Subject: RE: 16 Horsa Gardens - Bin storage location

drawing no: P050 job ref: 18_008 rev: A

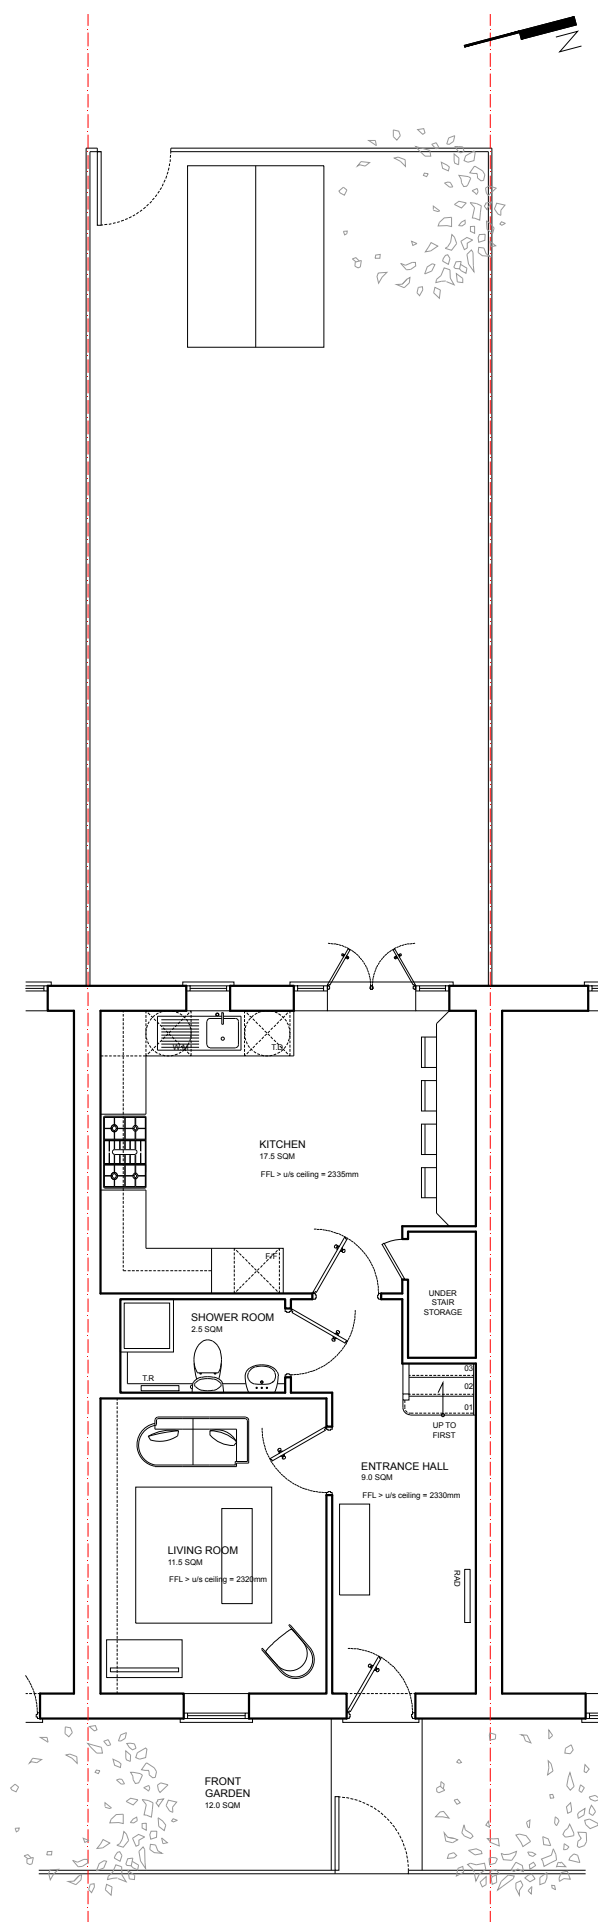
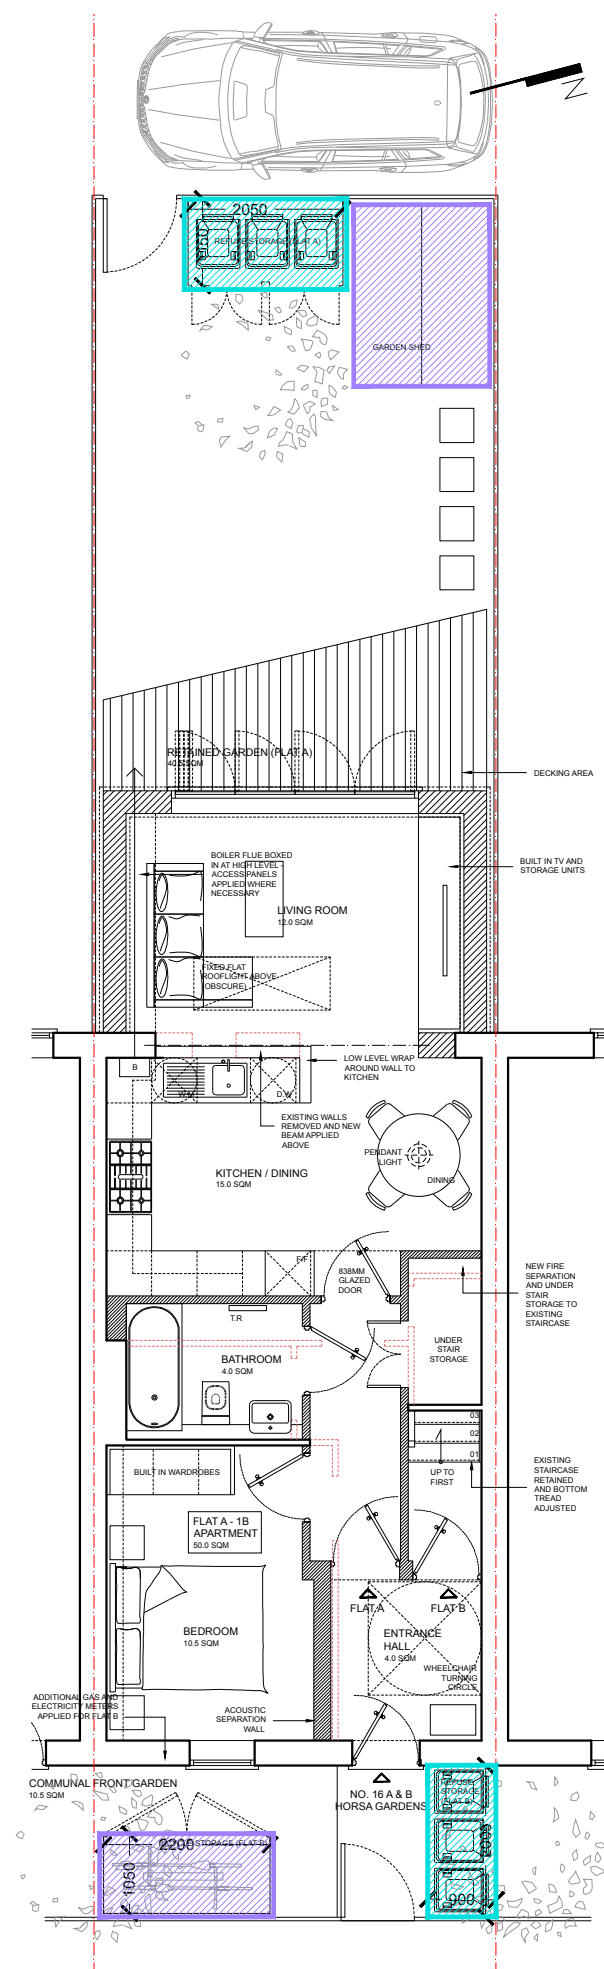
I have liaised with my colleague who looks after this area, she has advised that the bins are collected from the rear of the properties here in Horsa Gardens so in fact all bins for both properties will have to be stored there and then emptied from here as per the current arrangements.
